## HIA Addendum

In June 2017 a Heritage Impact Assessment report was completed for submission to the Department of Planning and Environment by the TCSA as part of the DA material for the proposed African Precincts development (NSW State Significant Development – Application No. 8008). Following reviews by the Department and the Office of Environment and Heritage, a number of issues were identified for clarification. Also, as part of the TCSA's response to the Departmental reviews, various components of the earlier proposal have been reconsidered. As a result of this, there are various changes to the proposal such that the earlier assessed potential for heritage impact has needed to be amended to reflect the revisions to the proposed design.

After due consideration by the TCSA of the extent of proposed works relevant to SSDA 8008 and on the basis of revised drawings by GDA (Landscape Architects) and TZG (Architects), the following main modifications are now proposed by the TCSA for the African Waterhole Precinct:-

PROPOSED MODIFICATIONS TO THE SIGNIFICANT VIEW CORRIDORS

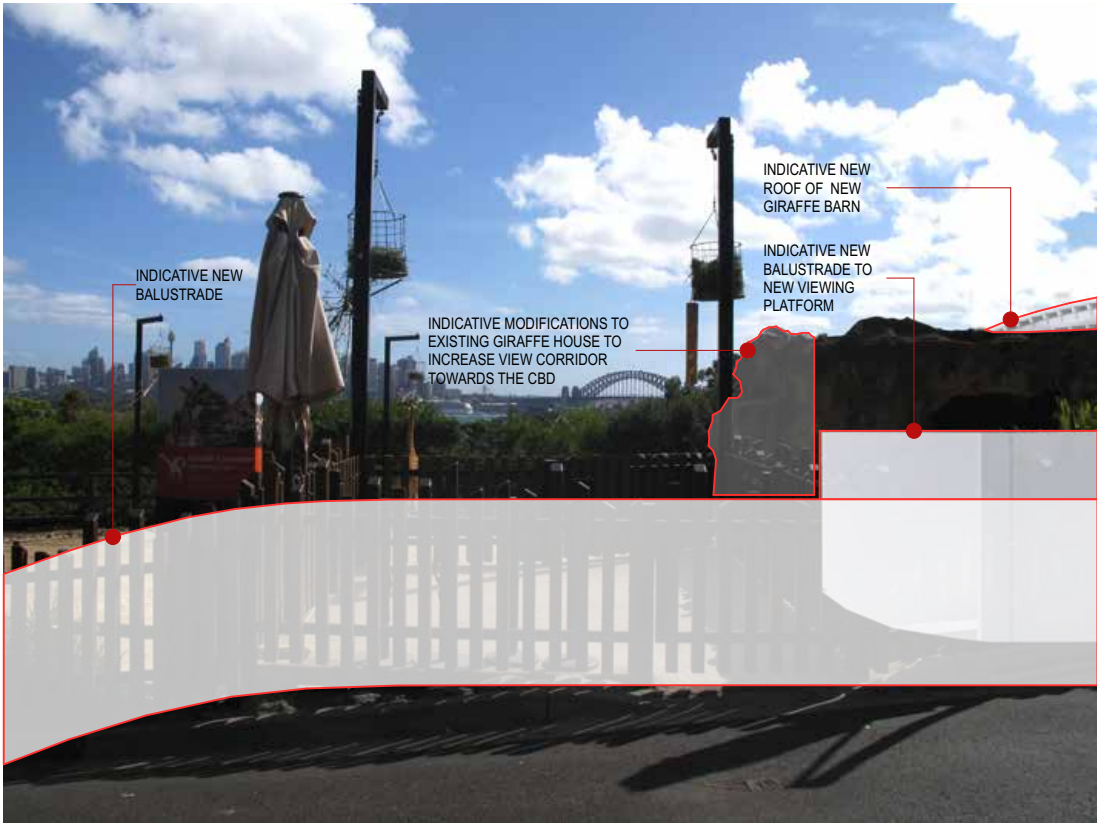
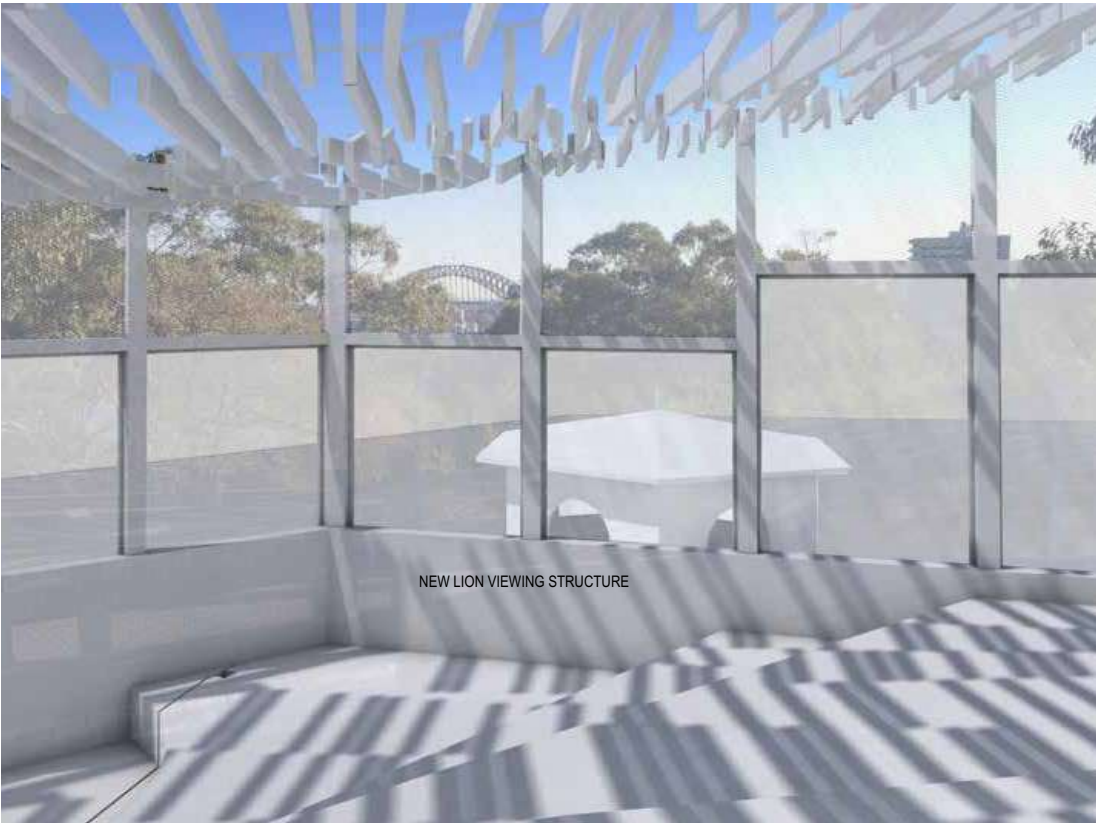
Attachment A also states that “although the HIA provides some consideration of view impacts, it does not consider the impact of development on specific views of heritage value to and from the site...”. Views within, to and from the African Precincts are included in the specific view assessments of the *Taronga Zoo Landscape Management Plan 2006*. Each of these views were numbered and mapped. It is these views of assessed ‘exceptional’ and ‘high’ heritage value that have been referred to in the HIA report where the potential impact of the proposed development has indeed been considered. This is discussed under ‘Setting’ for both precincts and summarised for example in Tables 7.4 and 7.7. A November 2017 Visual Impact Assessment by Ethos Urban has subsequently covered both these views and others in a new comprehensive consideration of site views.

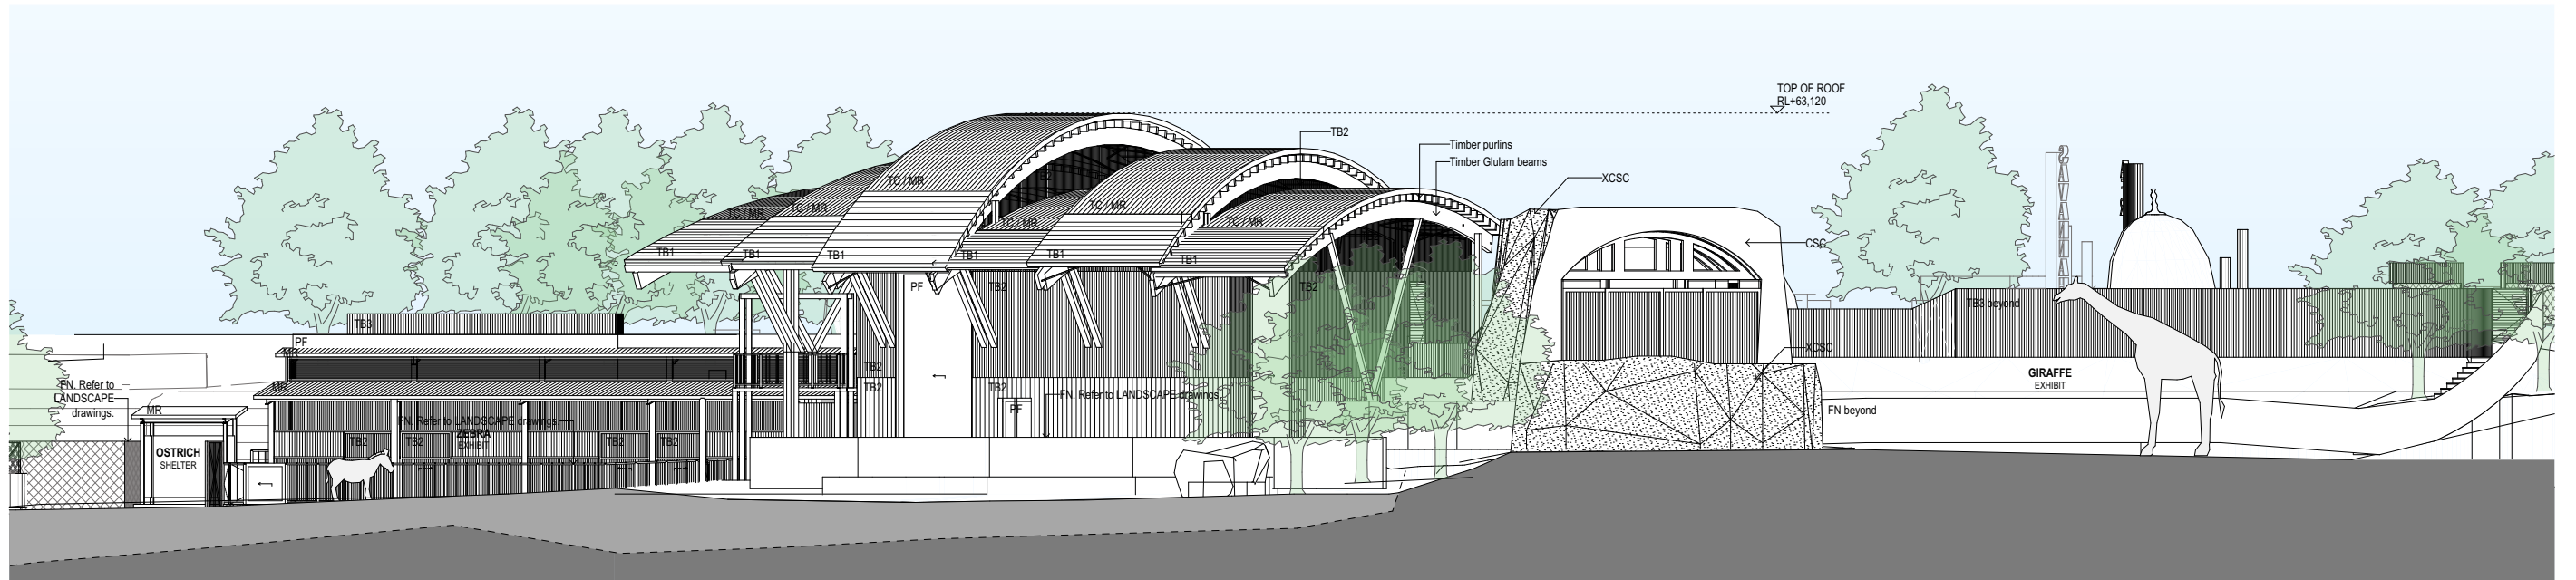
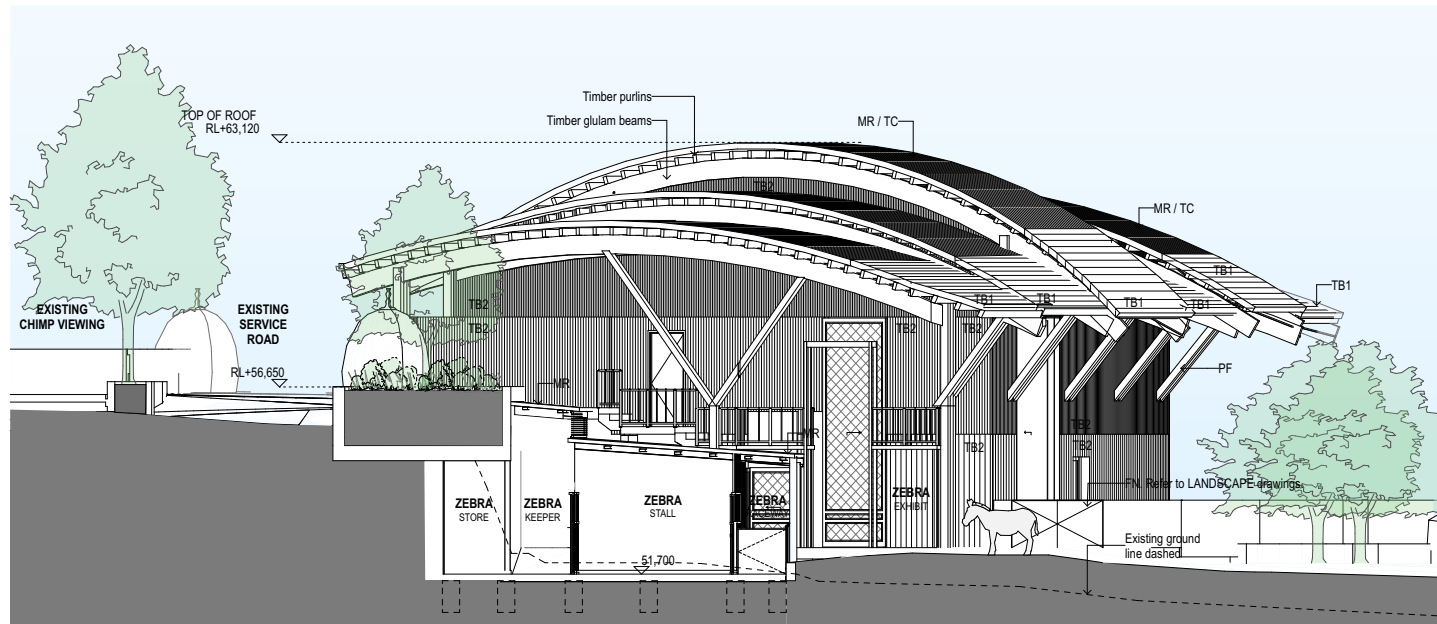
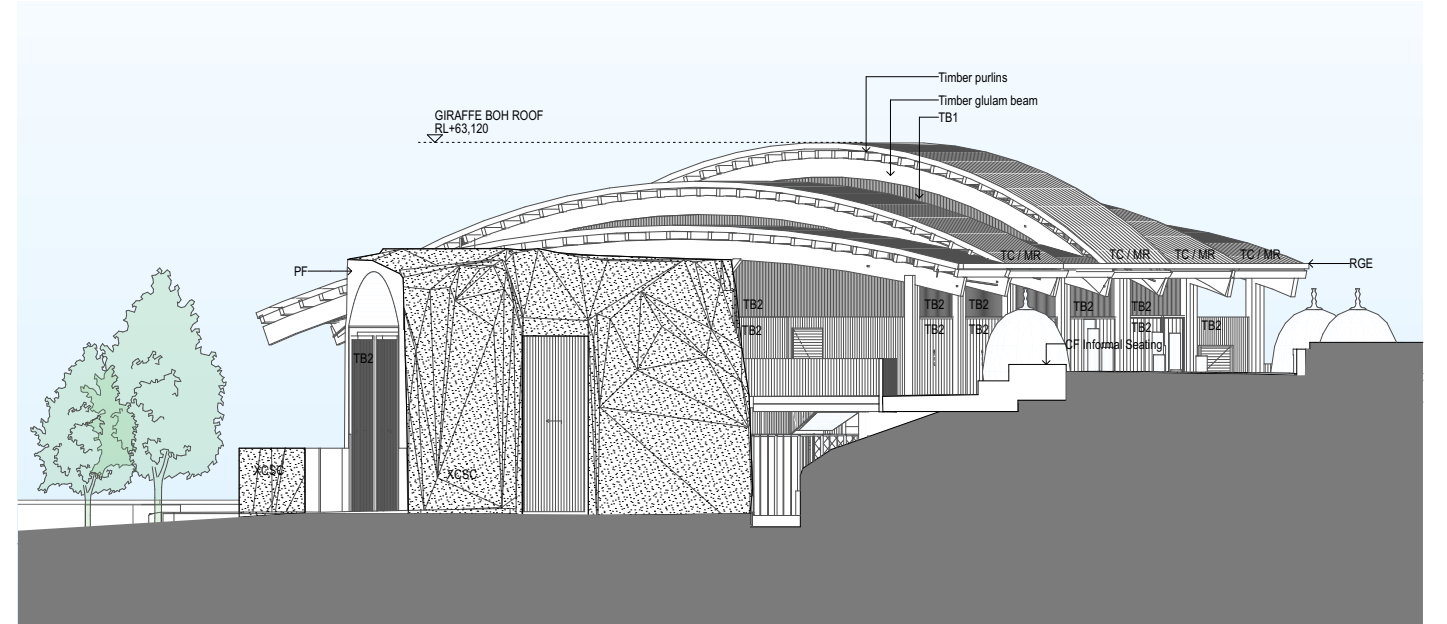
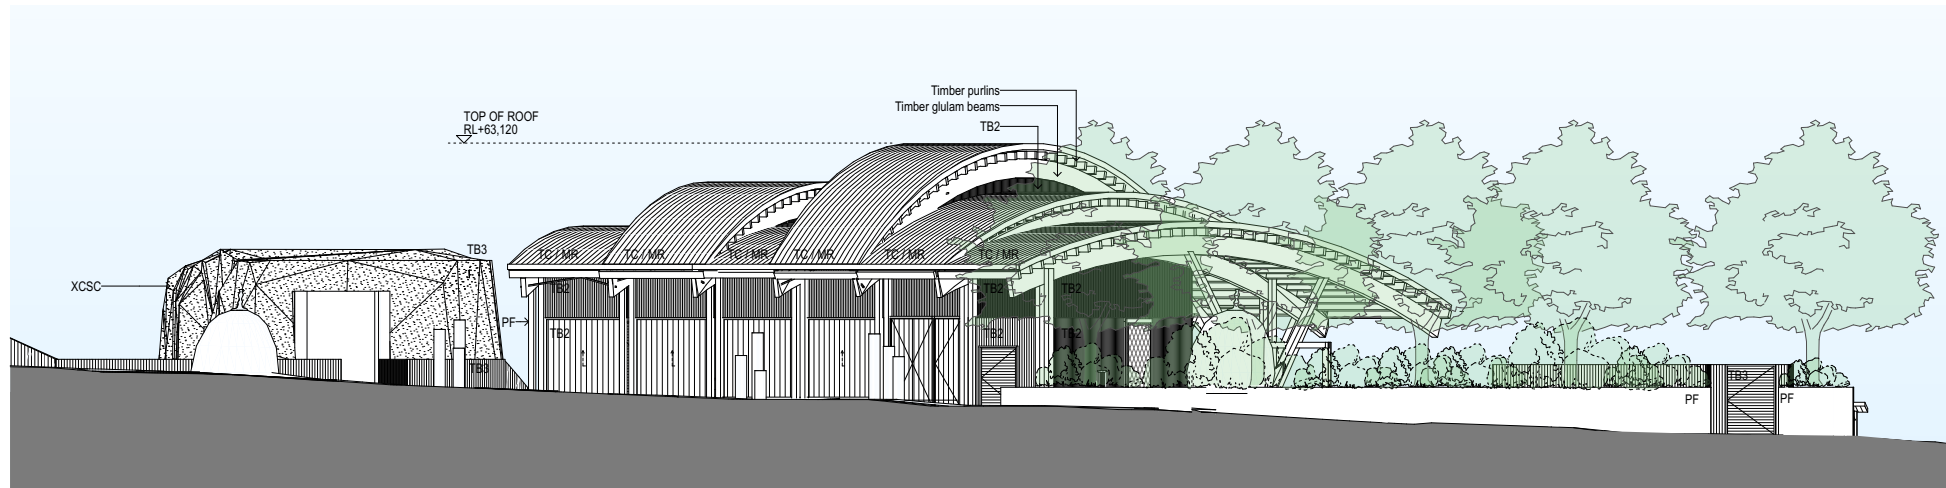
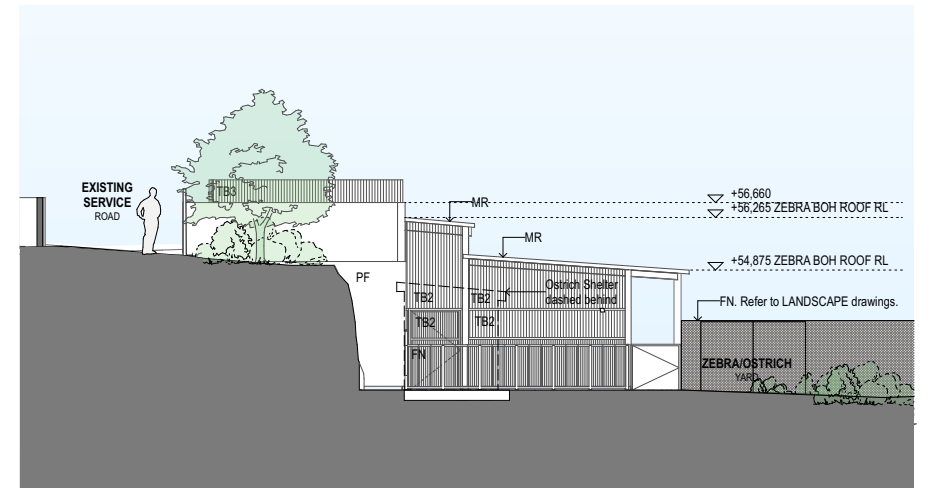
- \* The area of the new Giraffe Barn has been reduced by 34% to 238m<sup>2</sup> (excludes Zebra back of house – upper and lower ground areas are combined);

- \* The area of the new Giraffe House roof has been reduced by 49.4% to 325m<sup>2</sup>;
- \* The highest roof RL for the new Giraffe House has been lowered by 2.095m from RL 64.85 AHD to RL 62.755 AHD;

- \* A result of these changes is that the 1924 Giraffe House (Item 61B(a)) would now remain as a freestanding structure no longer encumbered, and dwarfed, by the addition of a larger roof over it;

- \* The 1924 faux-rock Giraffe House would no longer be dwarfed by the adjacent new Giraffe Barn as the latter is now proposed to be located further away and with a lower maximum roof height (reduced by 2m); and

The scale and form (including the roof area and height) of the new Giraffe Barn have been reviewed and replanned such that the revised proposal would have considerably less impact on the setting of the giraffe enclosure, the 1924 Giraffe House, key views and an appreciation of the giraffes themselves. More than the eastern bay of the Barn has been deleted, the entire structure moved further away from the 1924 Giraffe House and the height of its roof reduced by over 2m.
